Soils And Geo V_4.pdf Markup Summary

**FIG No. 19**

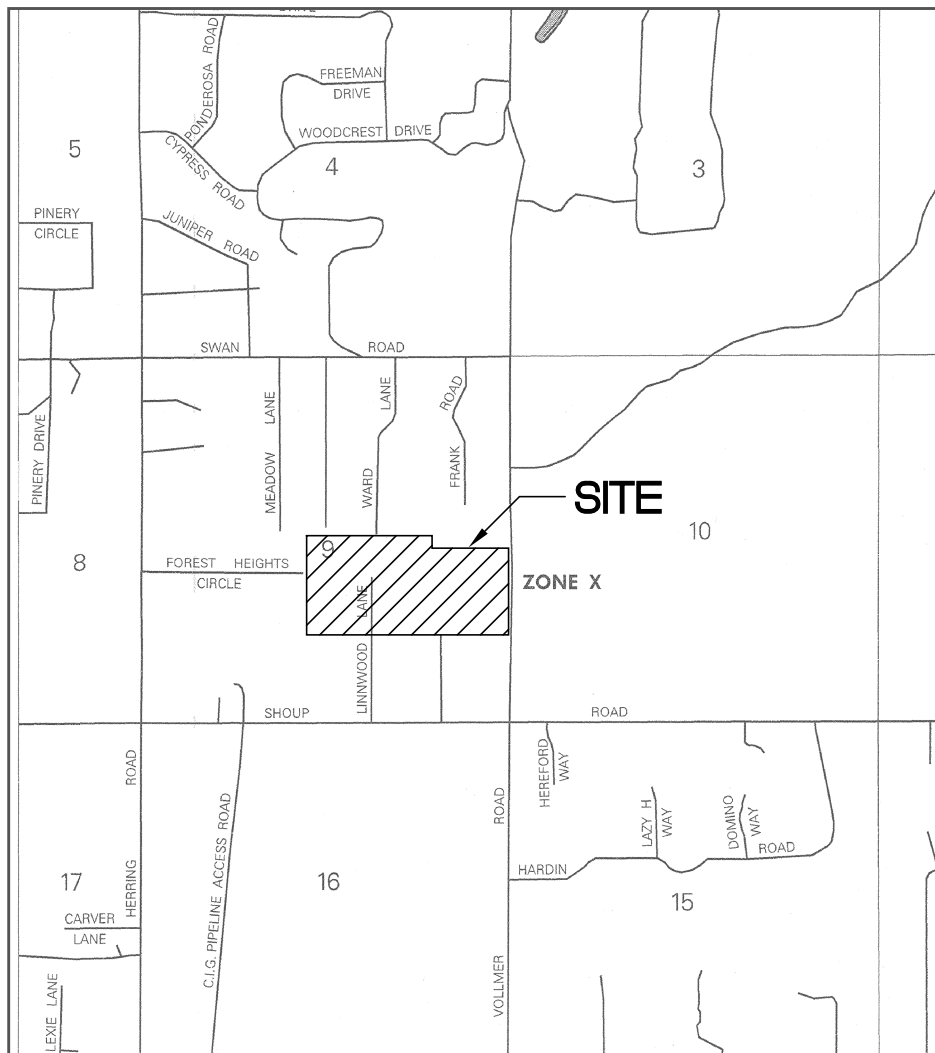
FEMA map is missing

FEMA map is missing
